**New Request for Advice – Taronga Zoo - Upper Australia Precinct (SSD-10456)
(Mosman Municipality)
Environmental Impact Assessment**

TAB A – TfNSW Comments – SSD 10456 EIS Taronga Zoo-Upper Australia Precinct

**SWEPT PATH ASSESSMENT**  
DRAWING NO. N192210-SK02-01

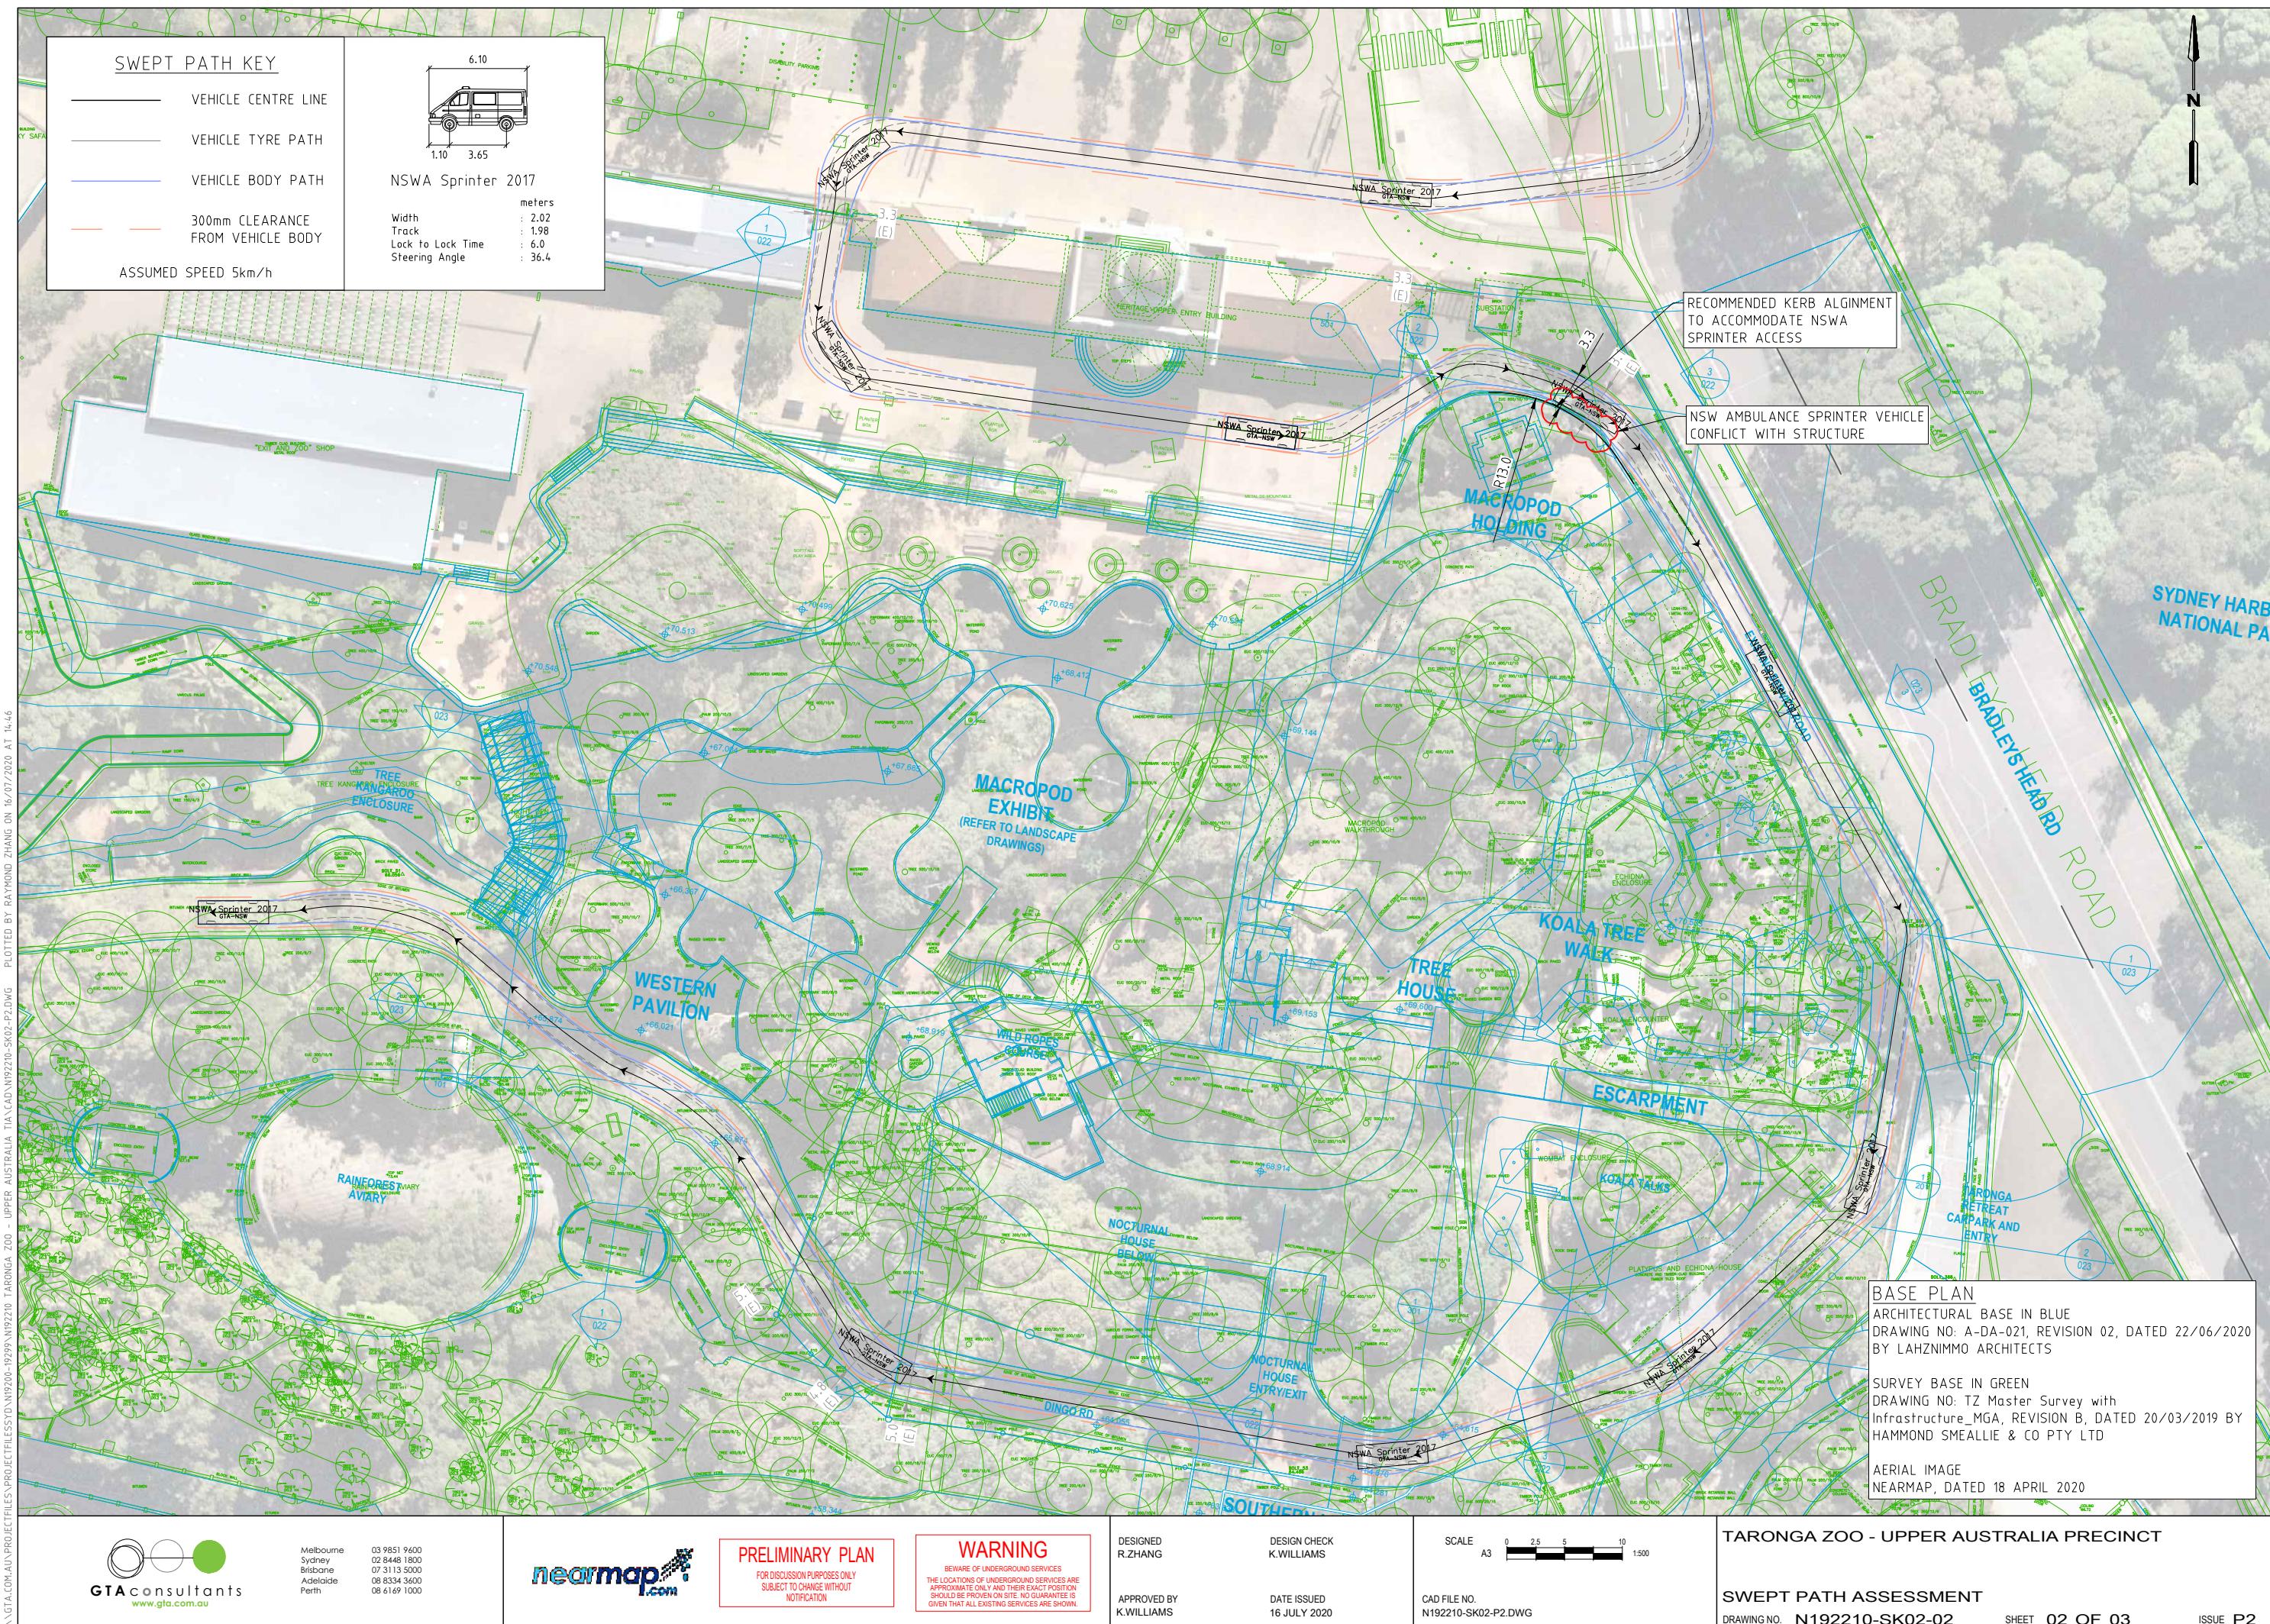
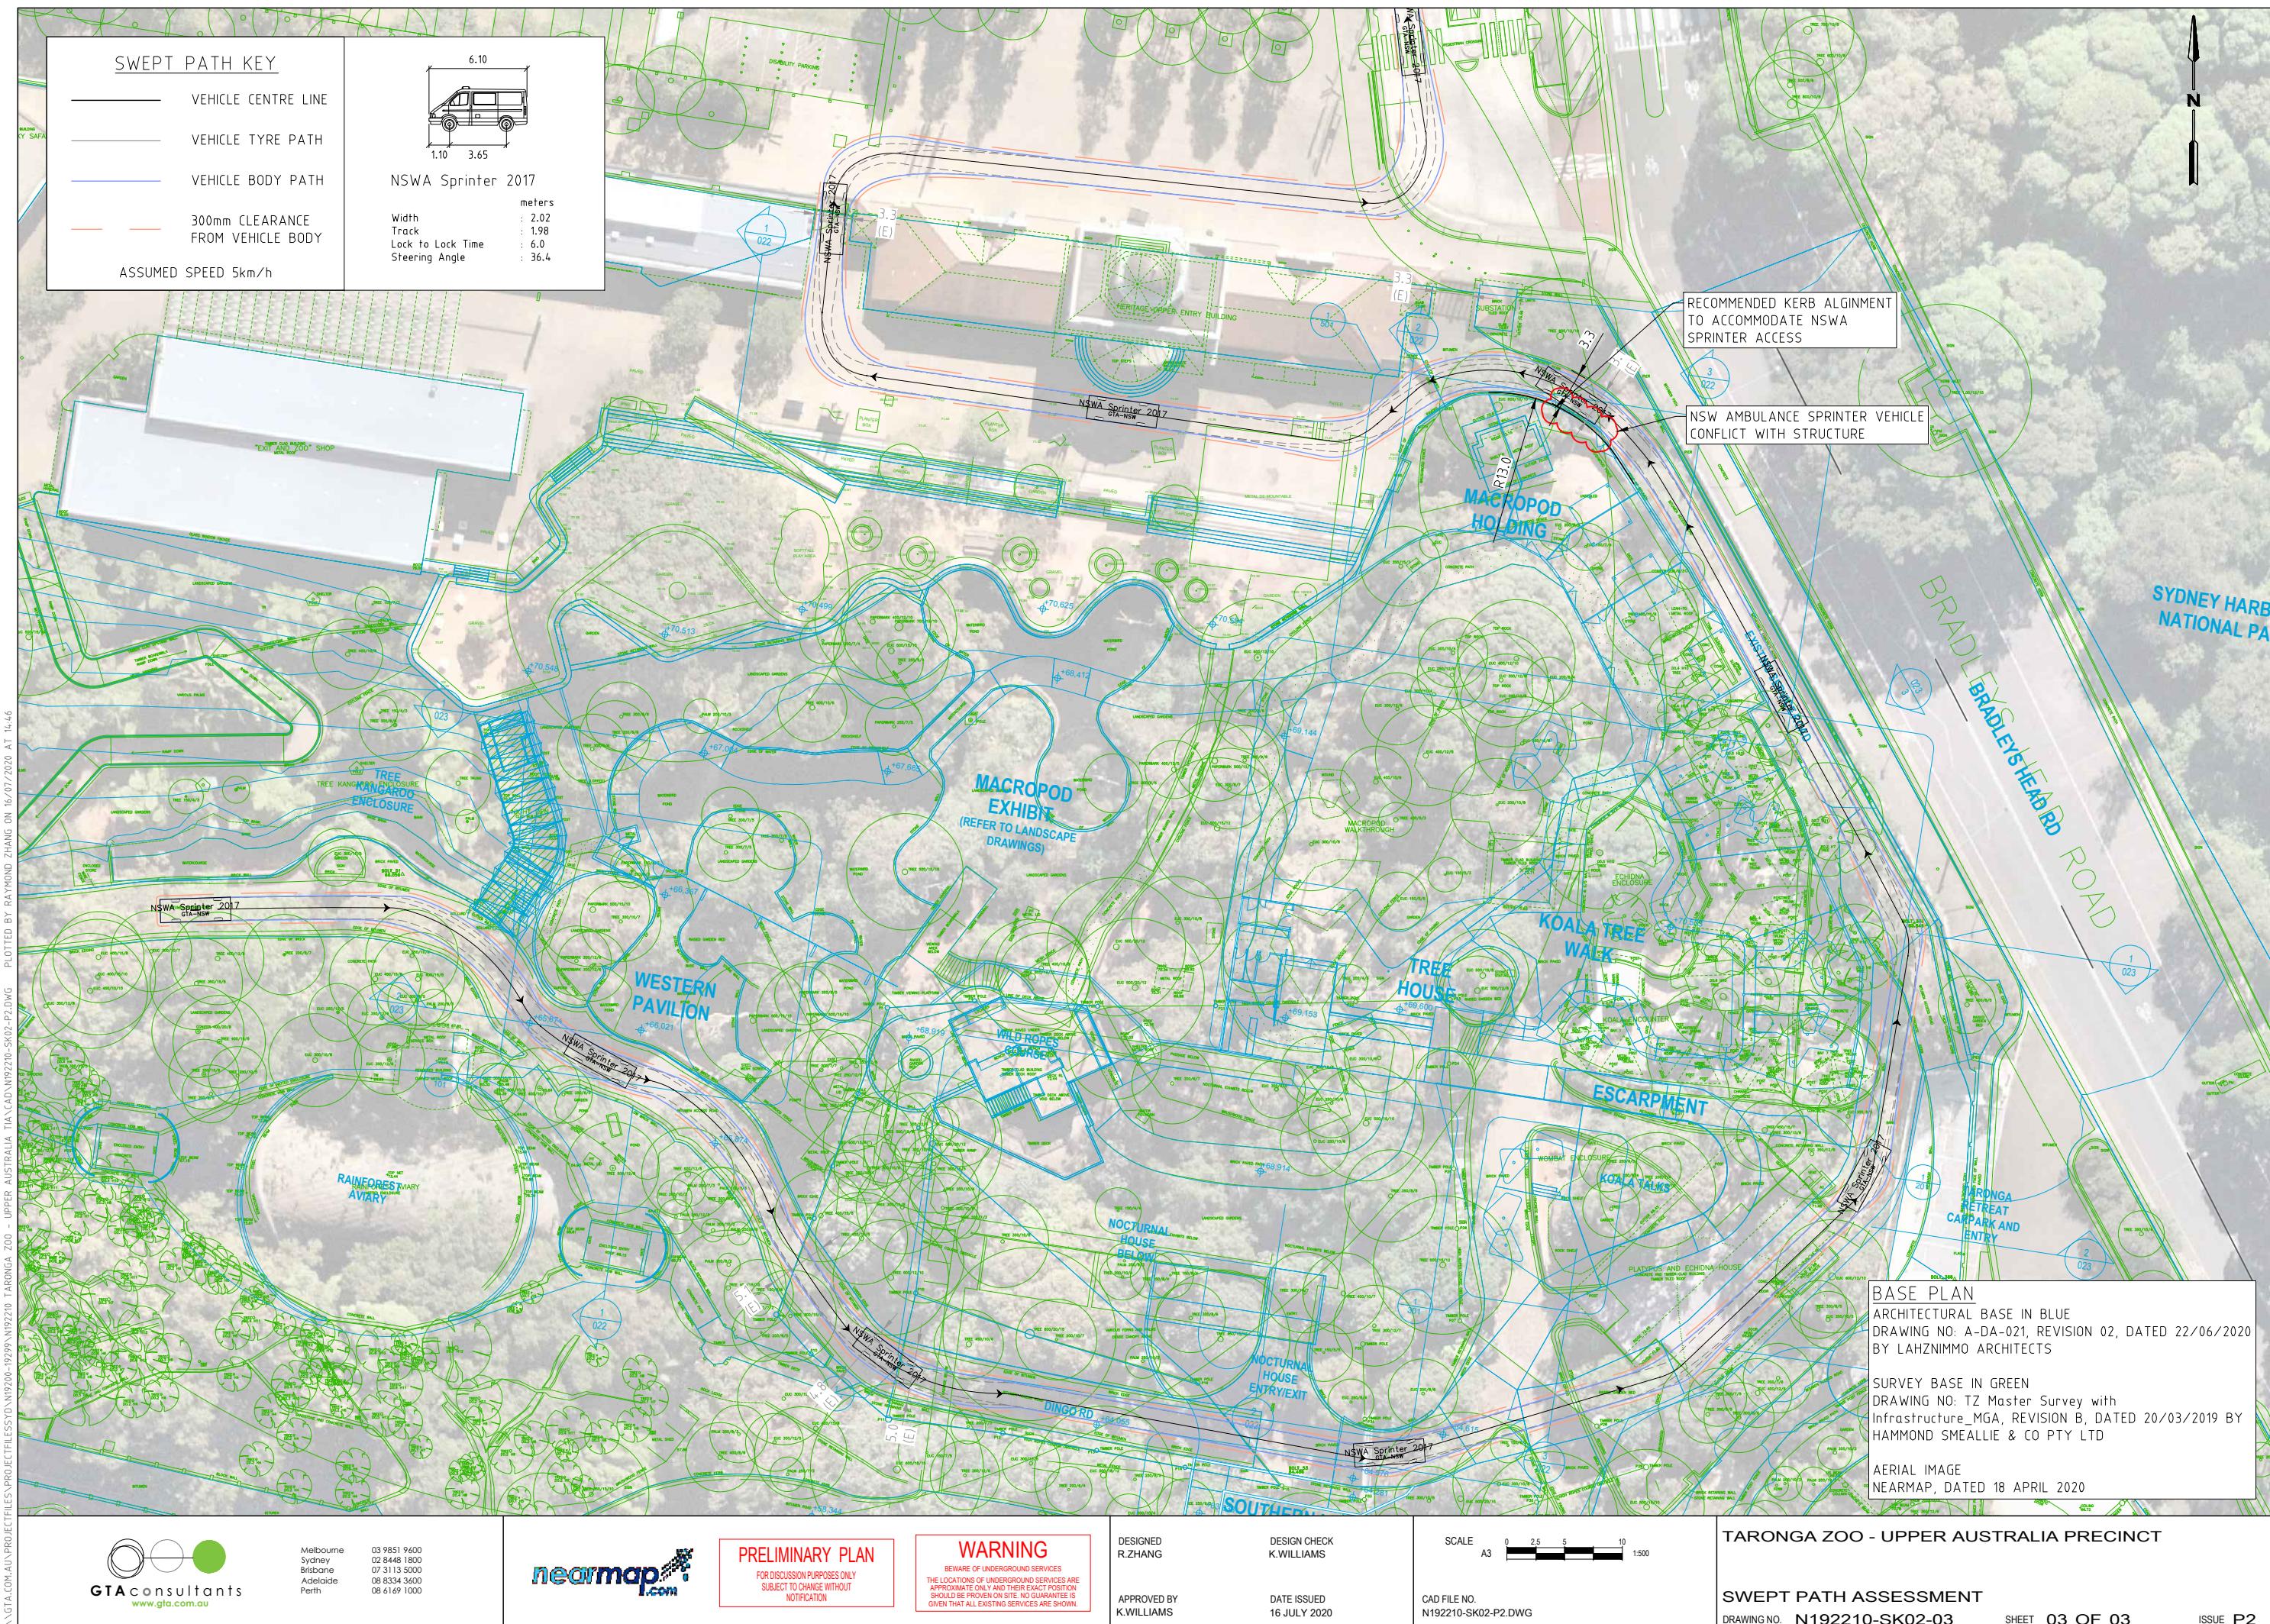
It is requested that the applicant be conditioned to prepare a detailed Construction and Traffic Management Plan (CTMP), detailing construction vehicle routes, number of trucks, hours of operation, access arrangements and traffic control. A swept path diagram should be provided to

demonstrate how the largest construction vehicles enter and exit the site in a forward direction. The swept path diagram should also demonstrate that the largest vehicle is able to turn around at the Taronga Zoo Wharf turning circle.
